KIRKLEES METROPOLITAN COUNCIL INVESTMENT & REGENERATION SERVICE

DELEGATED DECISION TO DETERMINE PLANNING APPLICATIONS

Reference No:	2023/62/92765/W
Site Address:	28, Savile Road, Lindley, Huddersfield, HD3 3DQ
Description:	Erection of single storey side and rear extensions with alterations
Recommending Officer:	Molly Storer

west elevation

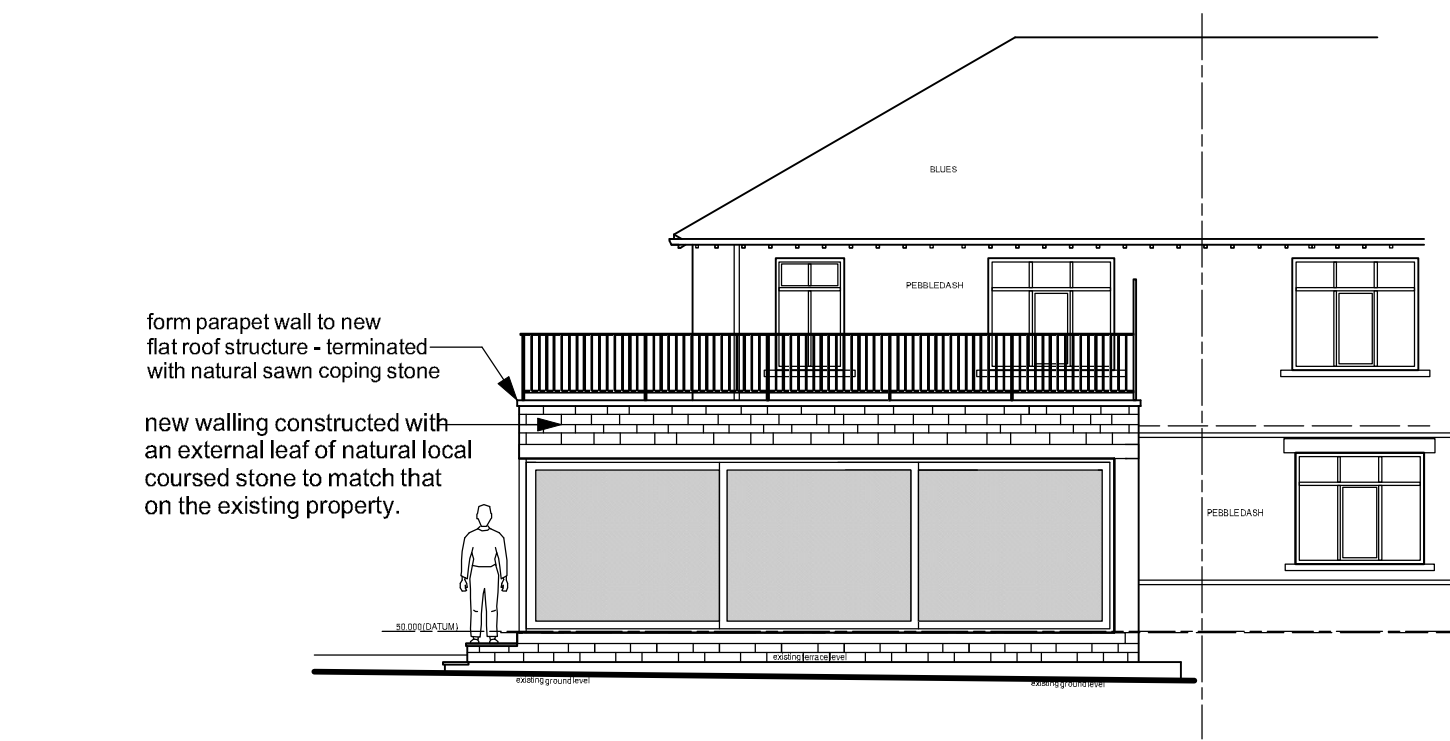
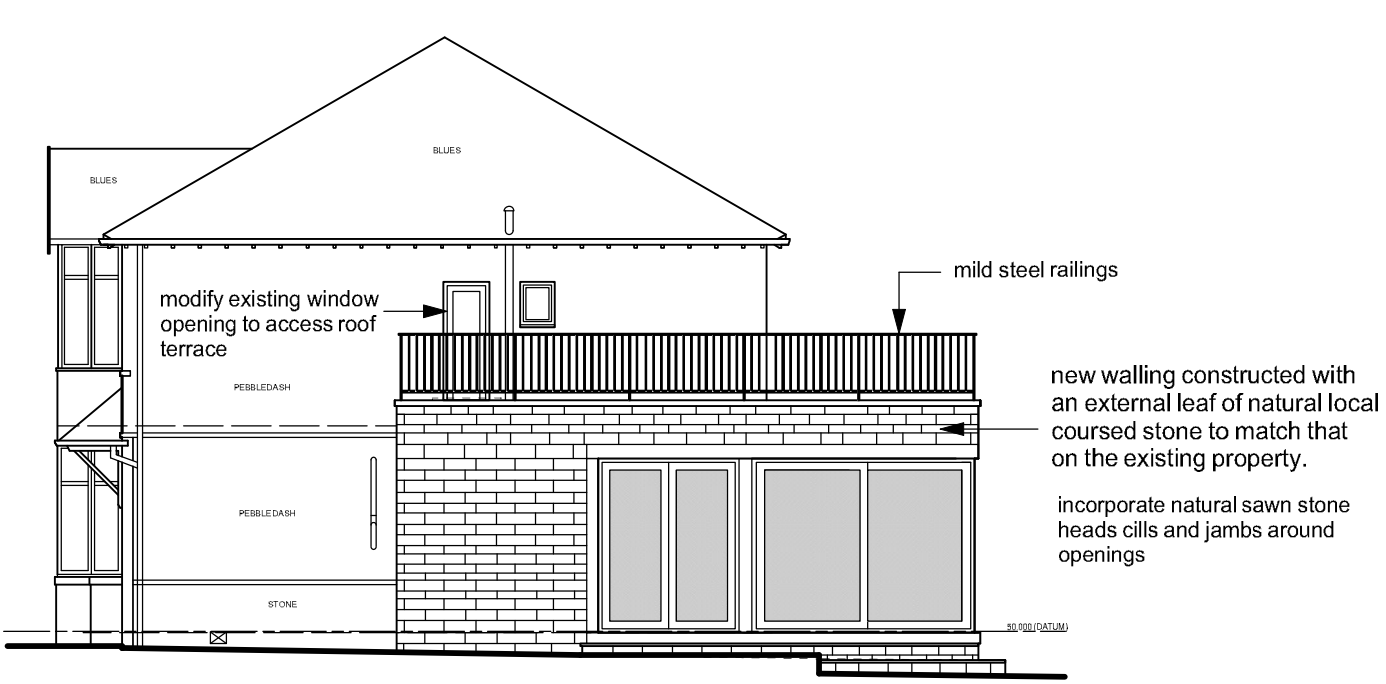
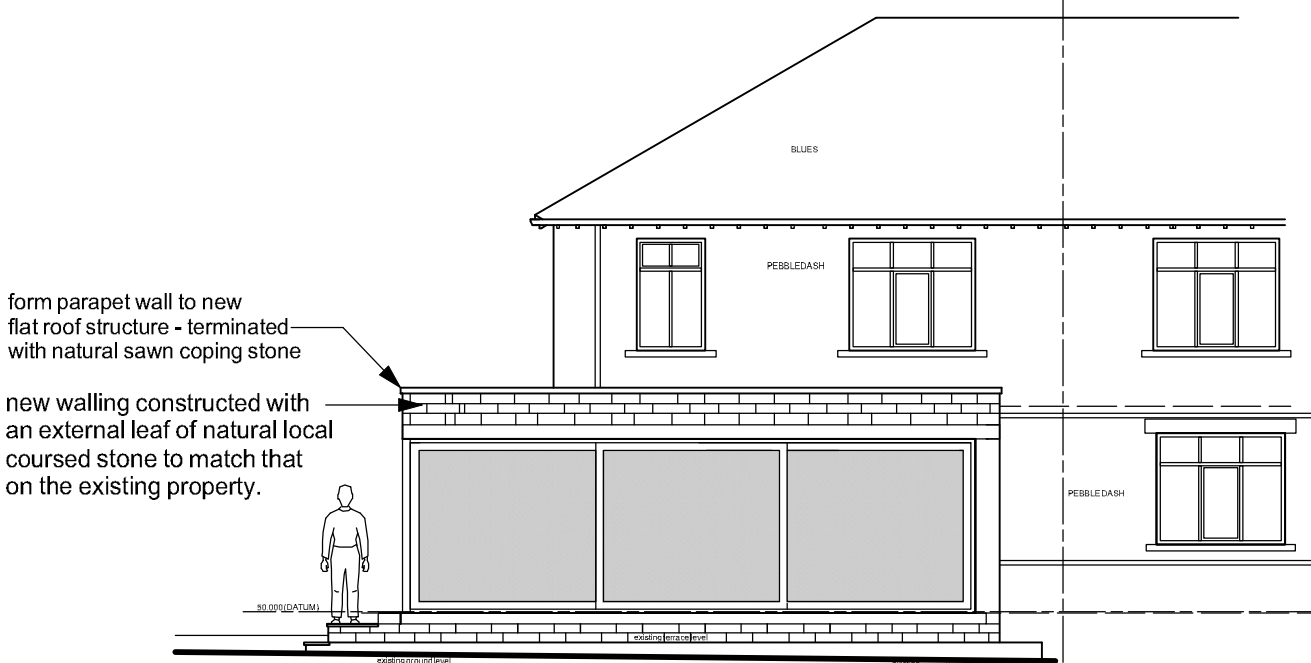
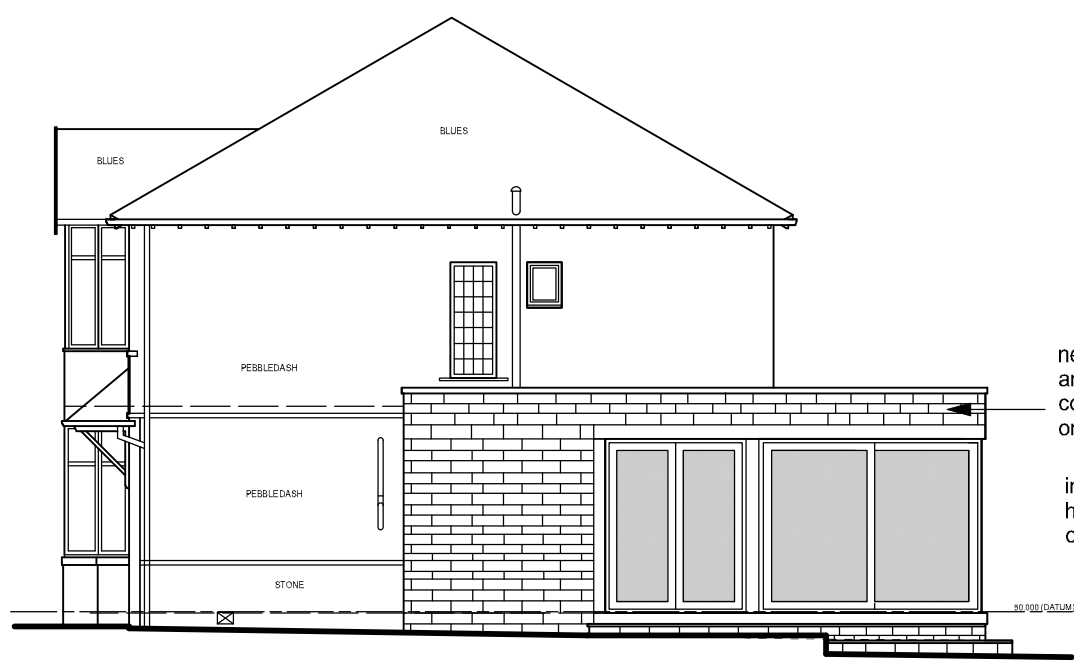
The agent responded with amended plans which removed the roof terrace and showed that the extension width fronting Savile Road would be reduced by 0.3 meters. However, the propped extension still raised concerns with respect to residential amenity, specifically the massing of glazing in the west elevation. This was communicated to the agent who submitted further amended plans with reduced glazing on the west elevation. These plans will be assessed in the following report. The description of development was amended to align with the updated plans.

ground floor & part site plan

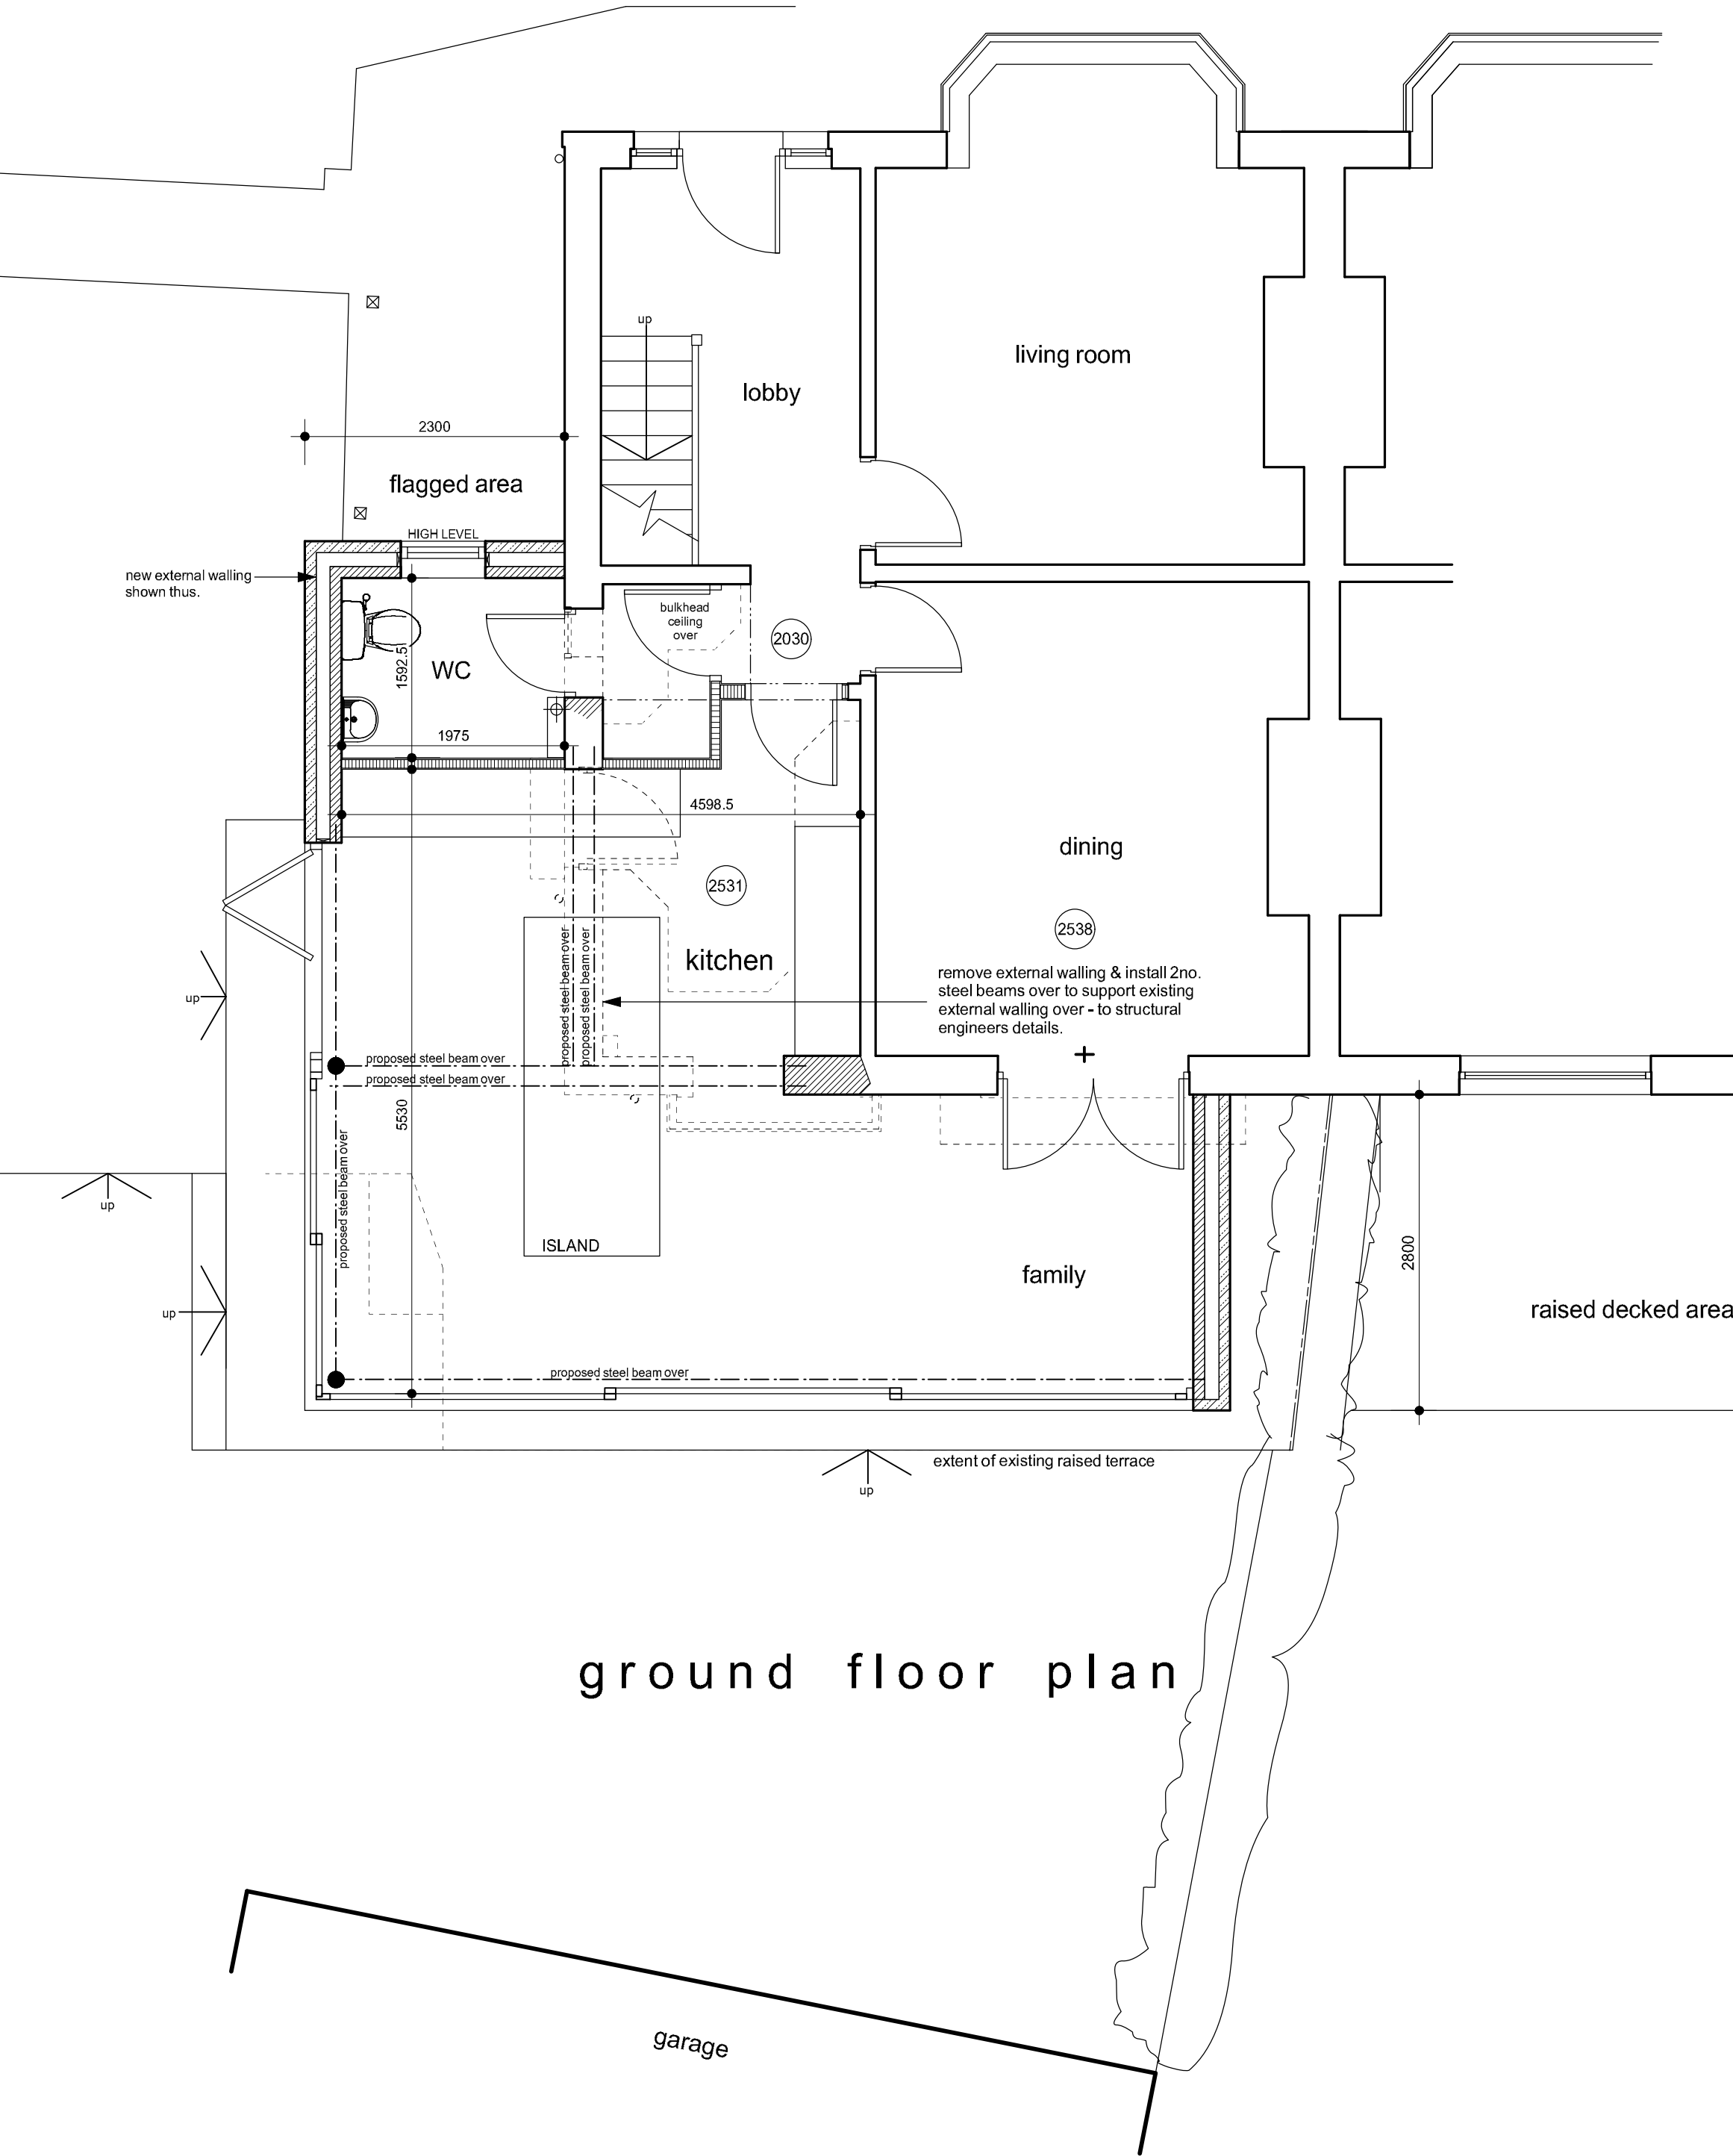
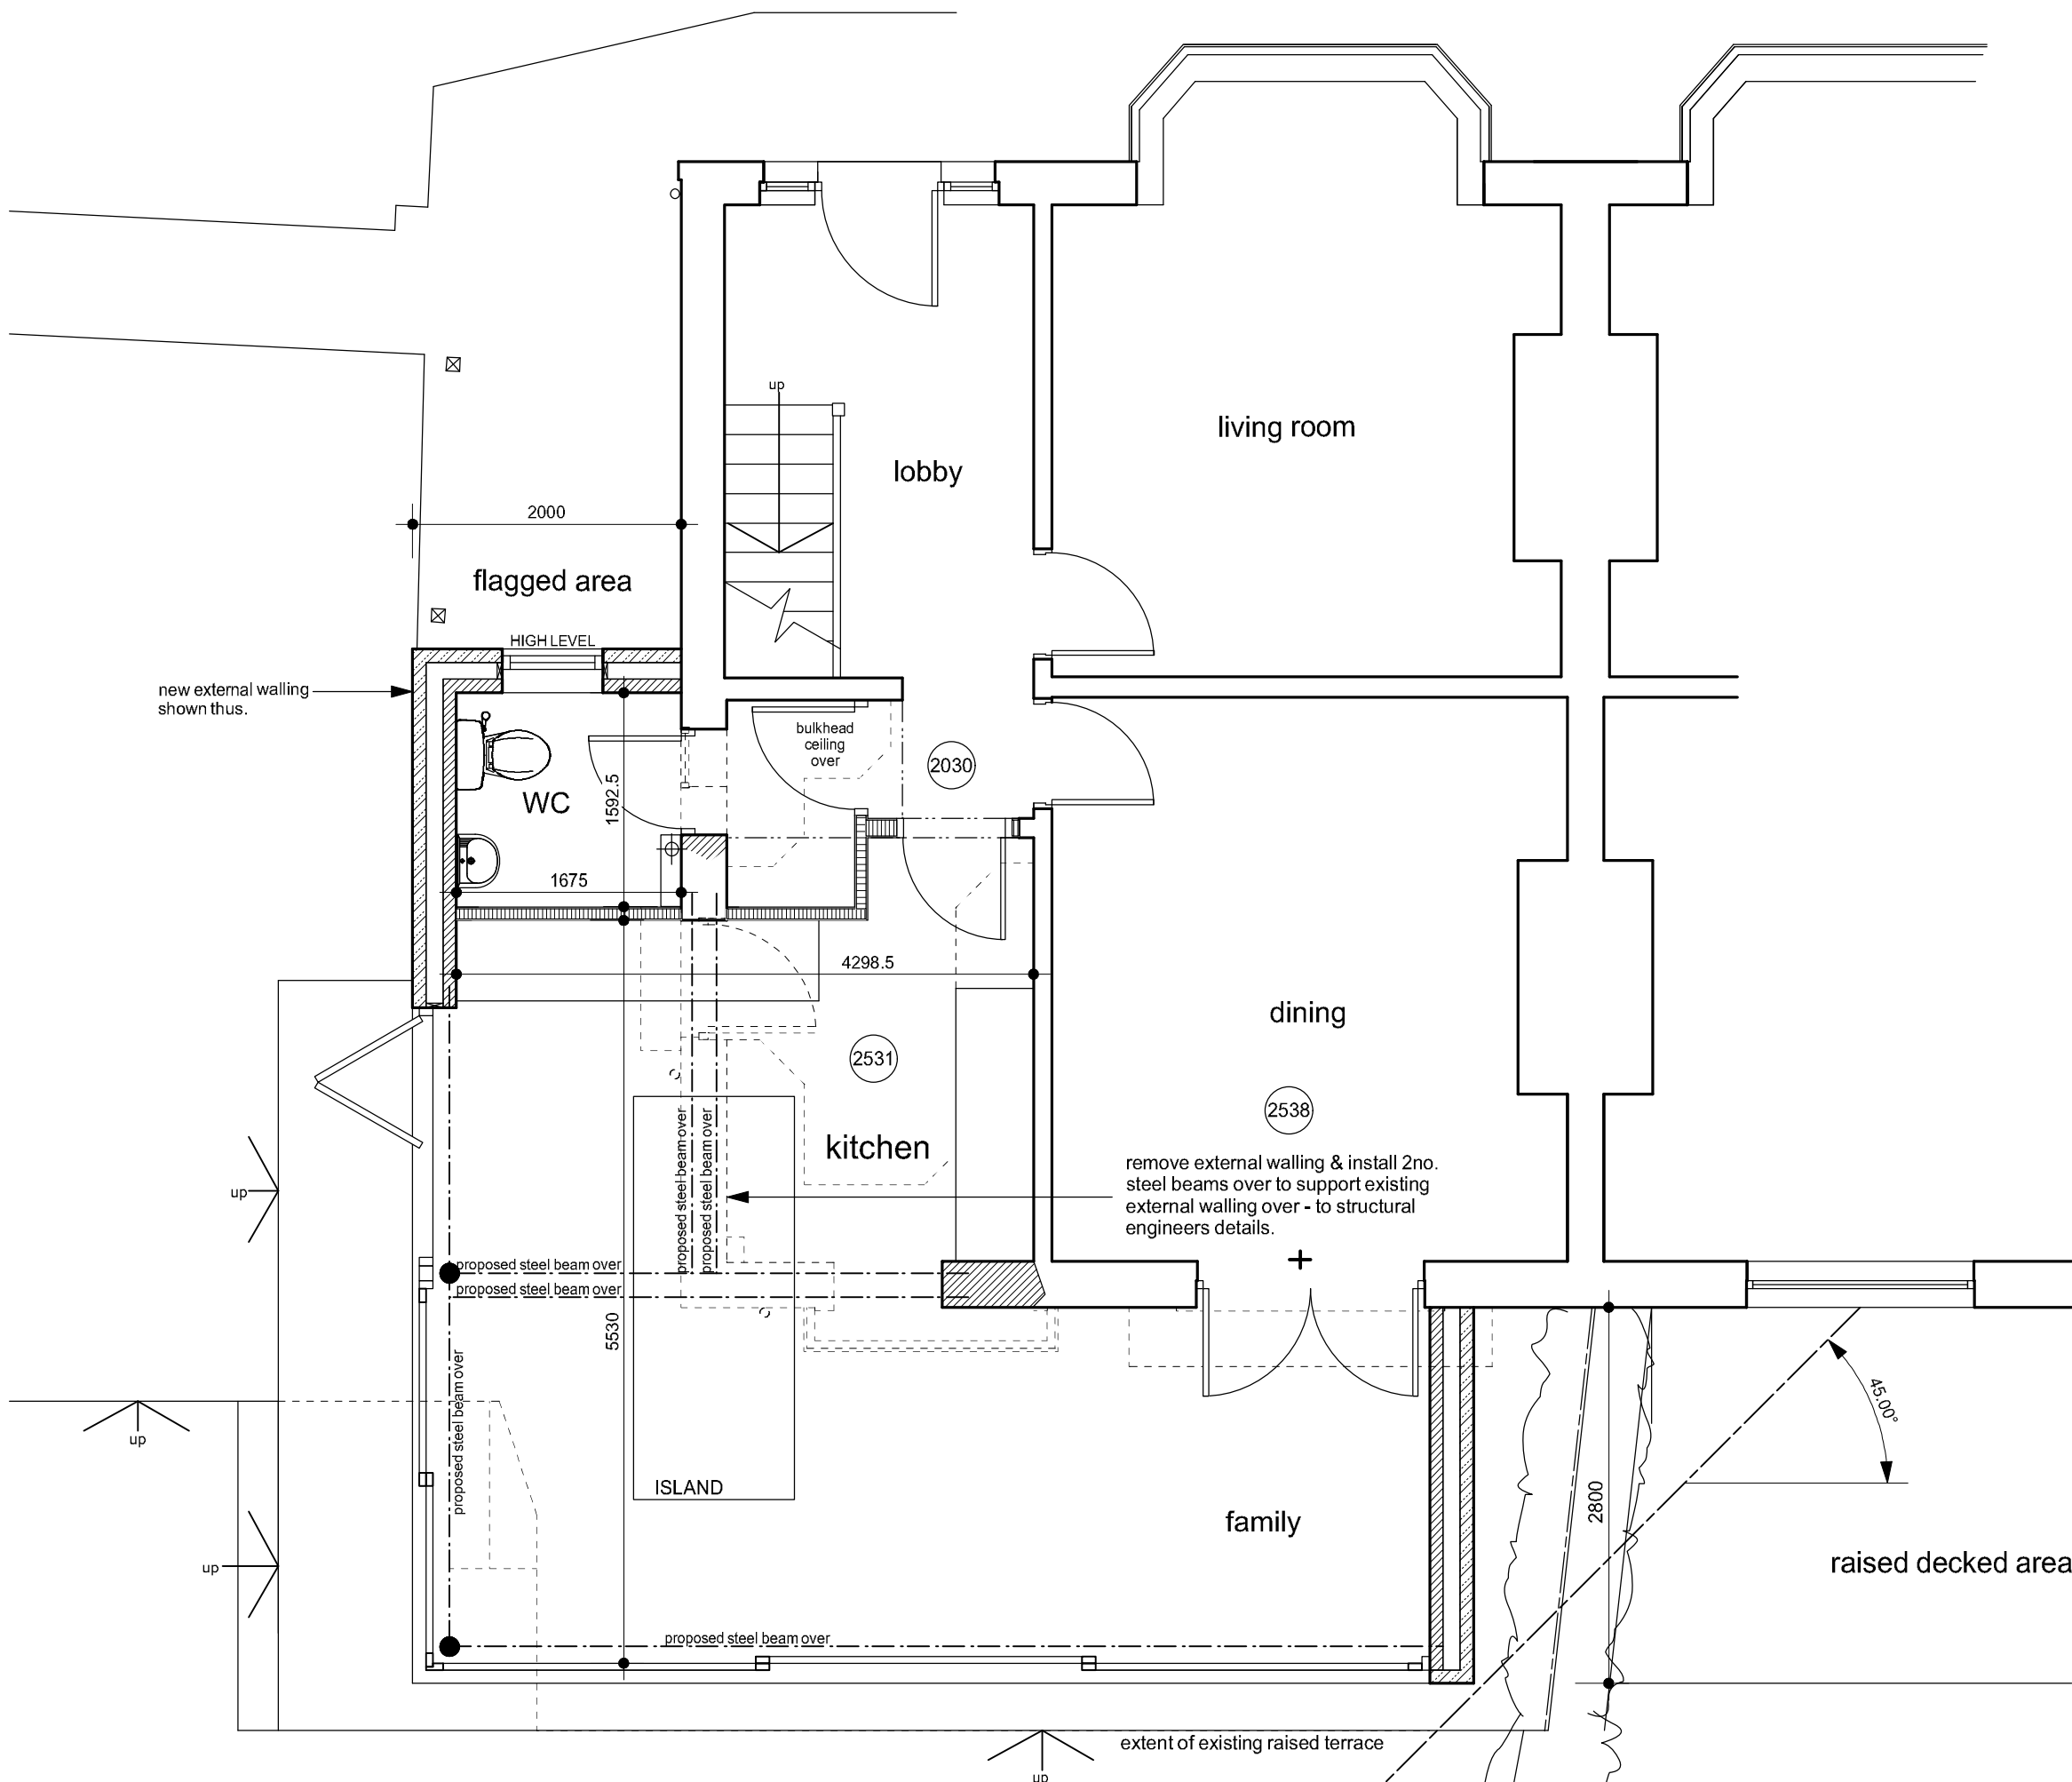
In addition, a reduction in the width of the side extension was requested to comply with paragraph 5.23 of the SPD, which states that on corner plots, side extensions should (inter alia) be set back from the existing building line on both streets. As submitted, the extension would not be set back from the existing building line on Howard Road. Therefore, a reduction in size and scale was recommended.
